Planning Application Ref: CM/10/18/OUT

Location: Mistletoe Farm, Horsemere Green Lane, Climping, BN17 5QZ

Description of works: Application for Outline planning permission with some matters reserved for redevelopment of the site with 1 No. 4-bed detached bungalow, 1 No. 3-bed detached chalet bungalows & 2 No. 3-bed semi-detached bungalows & associated works. Departure from the Development plan

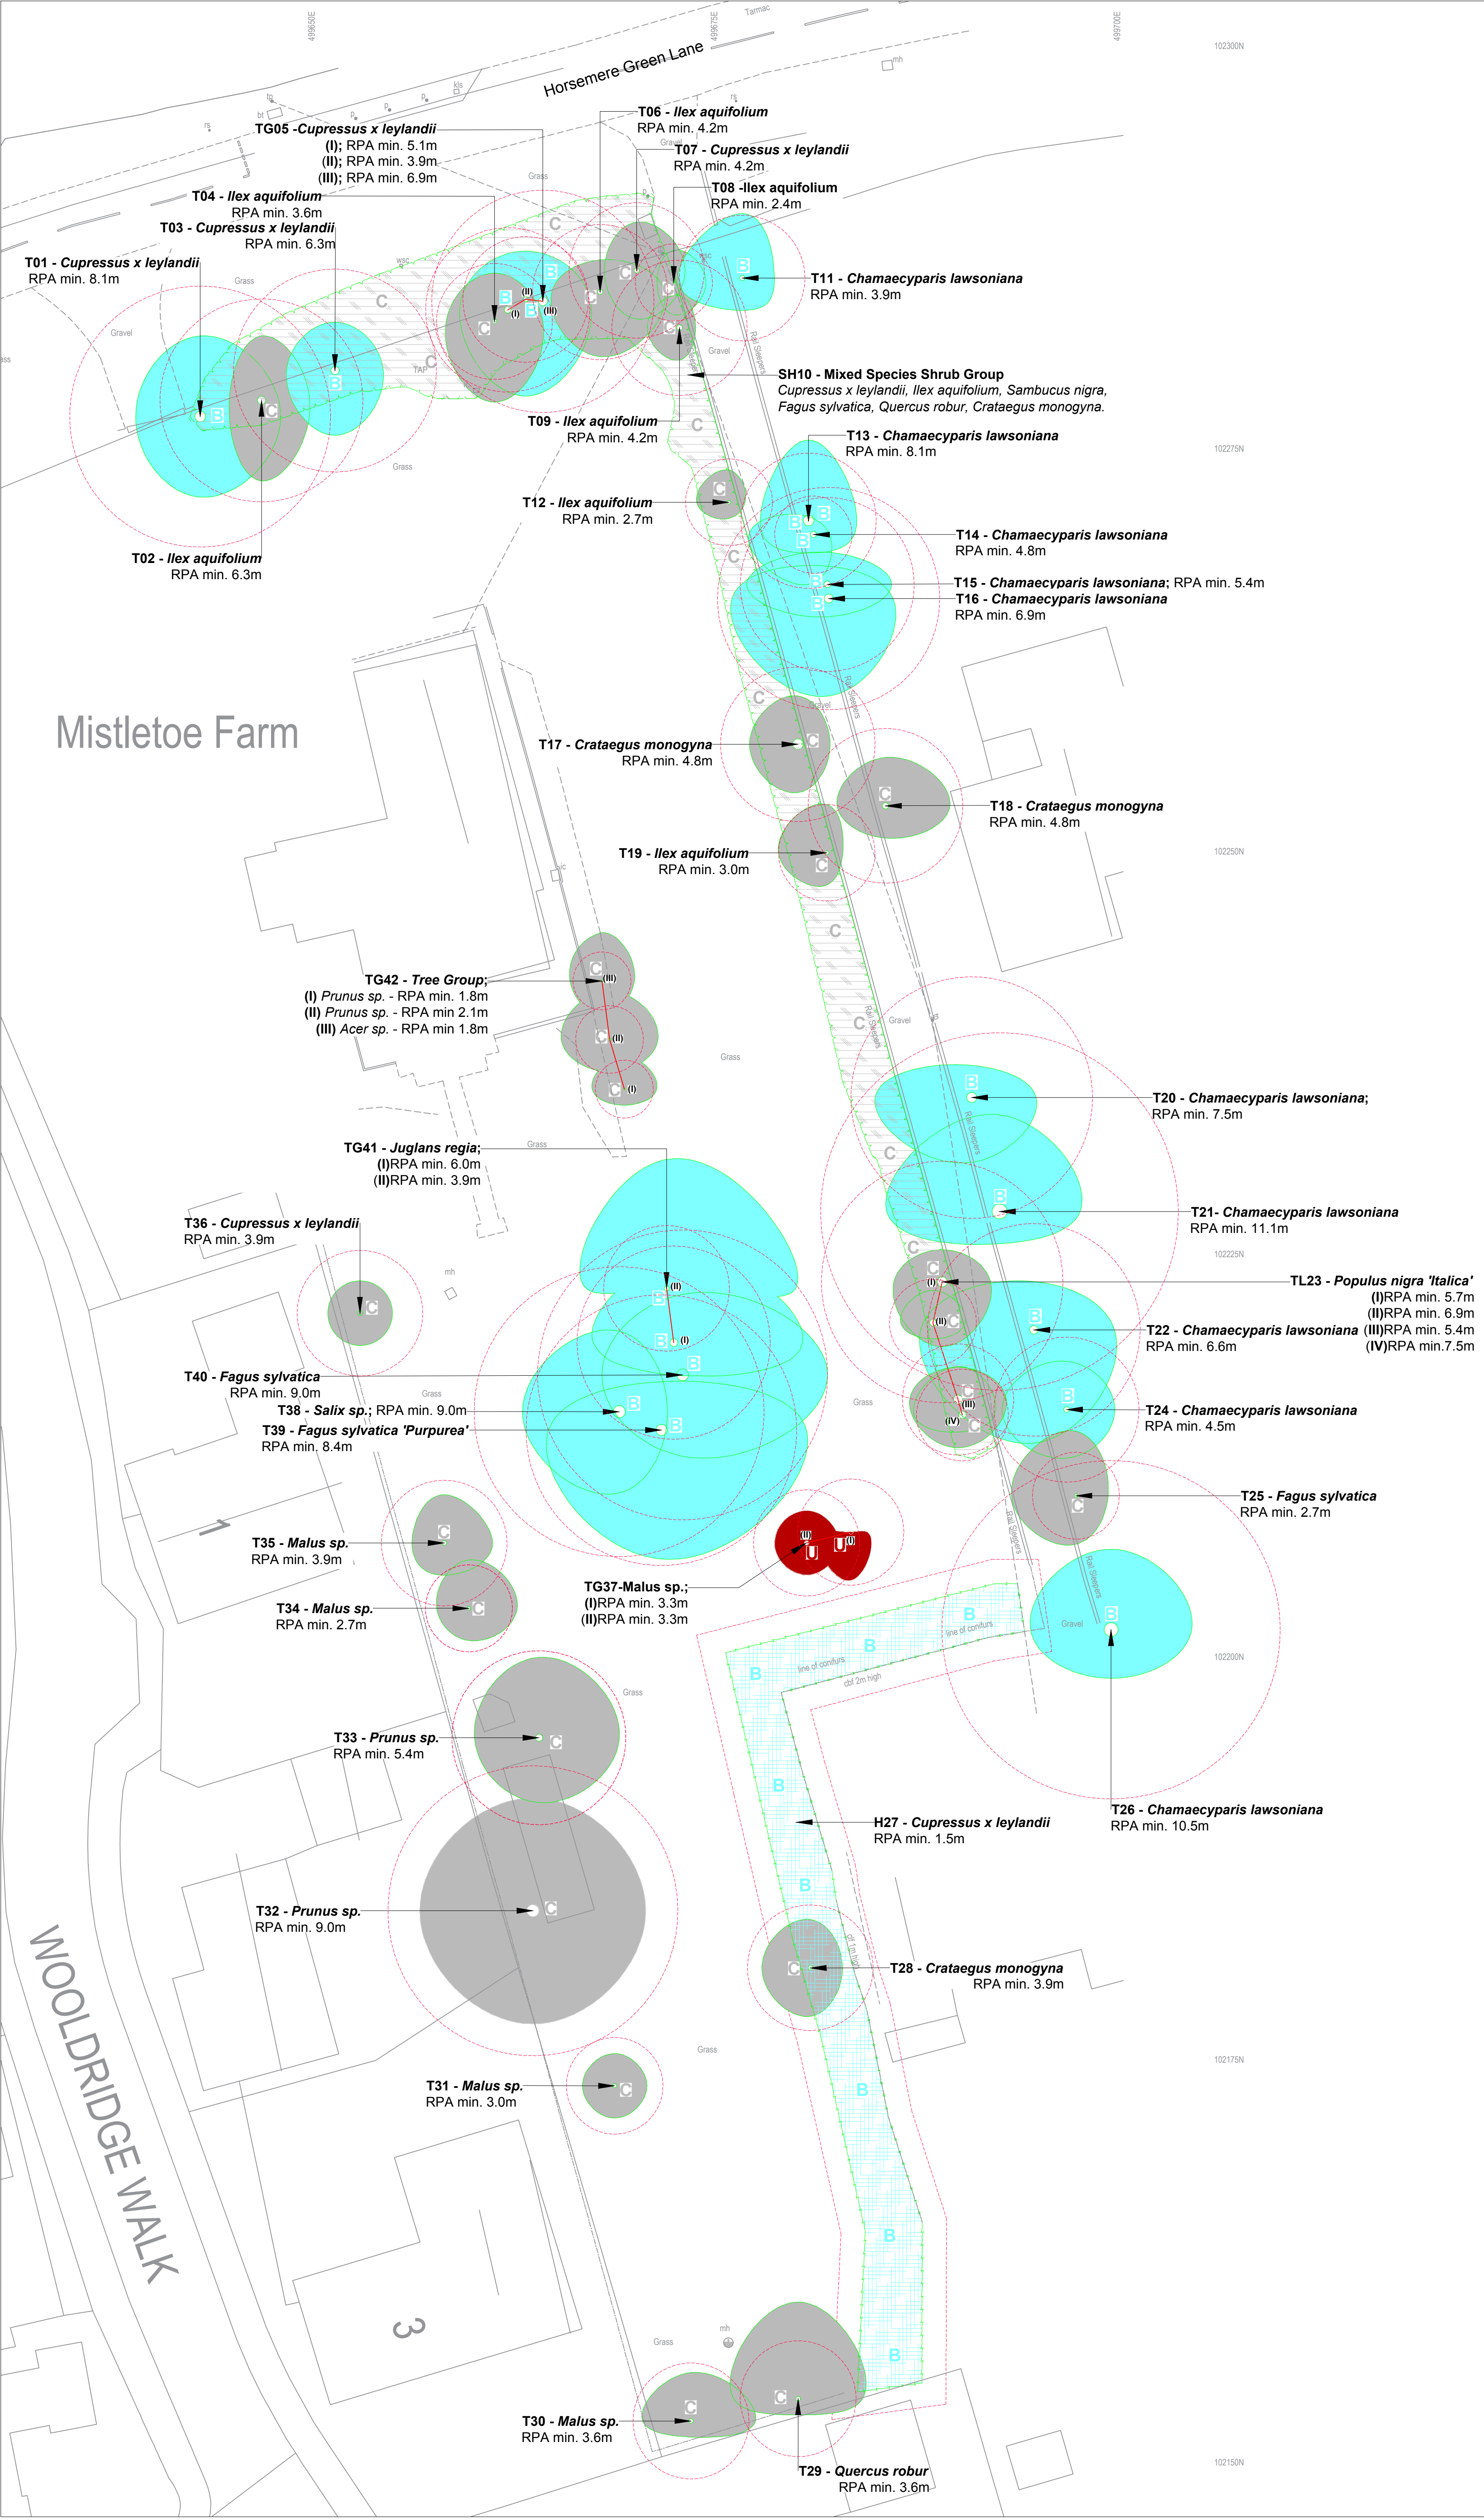
- The Tree Survey data submitted accords with the requirements of BS5837:2012 and I am broadly in agreement with the Suitability for Retention category ratings applied, with one notable exception. Although only of limited view at present, T40 – beech is an early-mature, healthy specimen that has benefited from group shelter afforded by neighbouring trees and has the potential to grown on and succeed those surrounding of shorter life expectancy. I regard it as a Category A tree (high quality) and it should be retained in harmony with any future development of this site. Indeed, the entire group within which it is centred could be made the subject of a group Order (defensible), although by preserving this one tree of high quality in the landscape, it is hoped the risk to the others will also be mitigated.

- The vast majority of trees identified for retention in the tree schedule are 3rd party/off-site, which the applicant is compelled to adequately respect and protect. Many of these are either over-mature and of limited safe, useful life expectancy or of limited public amenity value and visual interest; such that their retention cannot satisfactorily compensate for the extent of proposed tree removal within the site.

- Within the site perimeter, 66% of Category B and approximately 75% of Category C trees are listed for removal. Indeed, the number and type of dwellings proposed for this parcel of land is such that almost no trees of current and/or long-term value could realistically be retained.

- Trees to the west of the site alongside Wooldridge Walk (boundary of Mistletoe Farm) would provide the only screening between the adjacent residential area and this new development. Being low quality Lawson cypress of poor vigour and irregularly spaced, they do little to provide screening or visual interest and have no long-term value.

- I find the extent of proposed tree loss at this site unacceptable in relation to any positive benefits that may arise from the development.
- In respect of protecting the root systems of off-site trees that run the full length of the sites east boundary, I welcome the proposal of a 'No-dig' solution, although it must be noted that that element is very ambitious and carries a high risk of accidental damage. It remains to be seen whether or not satisfactory ground levels can be achieved to implement the required level of tree protection.

- I recommend **REFUSAL** for this application.
- I recommend the making of a Tree Preservation Order to protect the Category A beech tree (identified on the applicant's submitted tree retention and protection plan as T40). I attach a TEMPO form and site plan to assist you in making this order.
